Engineers Comments Regarding Surface Water Drainage

Application Reference:	Y/47/26/HH	Reviewer Reference:	ADC/EXT5/AF
Planning Officer:	Silvie Steiningerova	Date of Review:	24/08/2026
Site Name:	Flints Hoe Lane Flansham PO22 8NP		
Application Description:	Part single, part two-storey rear extension, dormer extension and alterations to fenestration.		
Assessment Number:	1

Proposed Ground Floor Plan

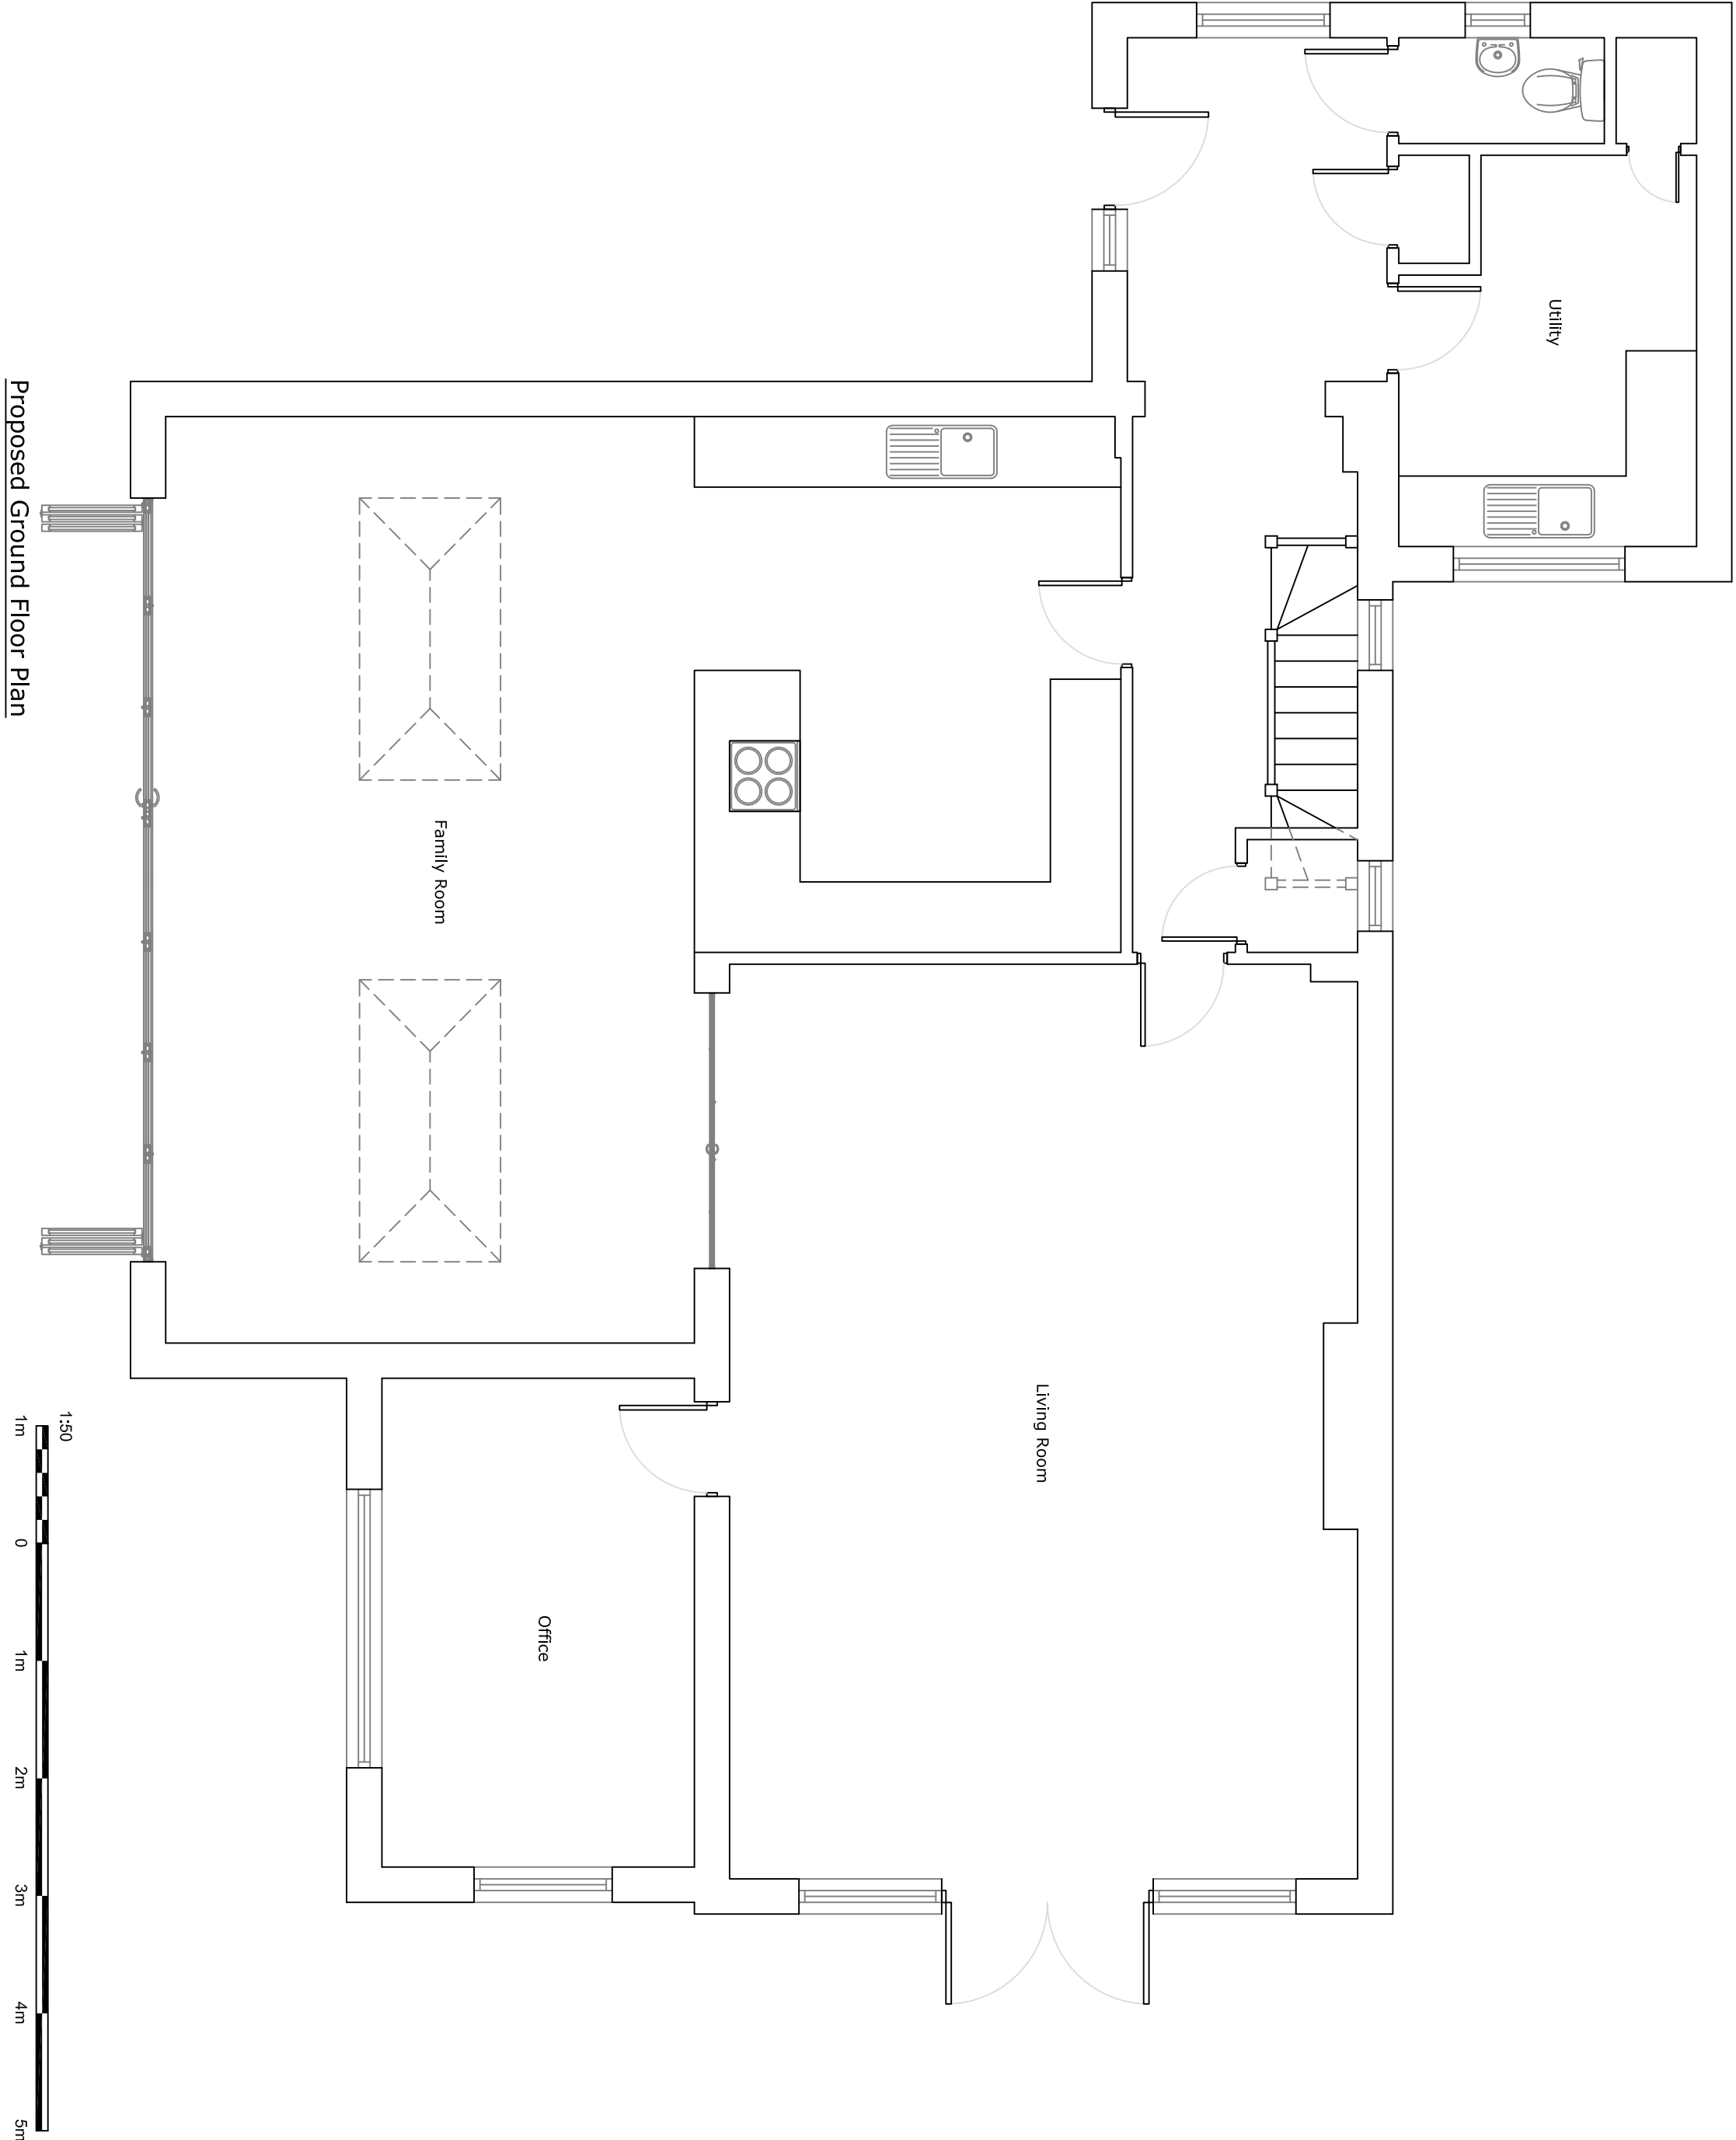
1.2. The Lidsey Drainage Statement notes the extra roof area will be drained to soakaway but no further details or evidence is provided.

3.1. There are no calculations provided with the planning application for management of extreme rainfall. The additional roof area should be attenuated, or the infiltration feature sized to accommodate large return period storms.

3.2. The drained area should be clarified and runoff calculated for the design storm based upon up to date rainfall data. Guidance is provided on ADC webpages - <https://www.arun.gov.uk/surfacewater>.
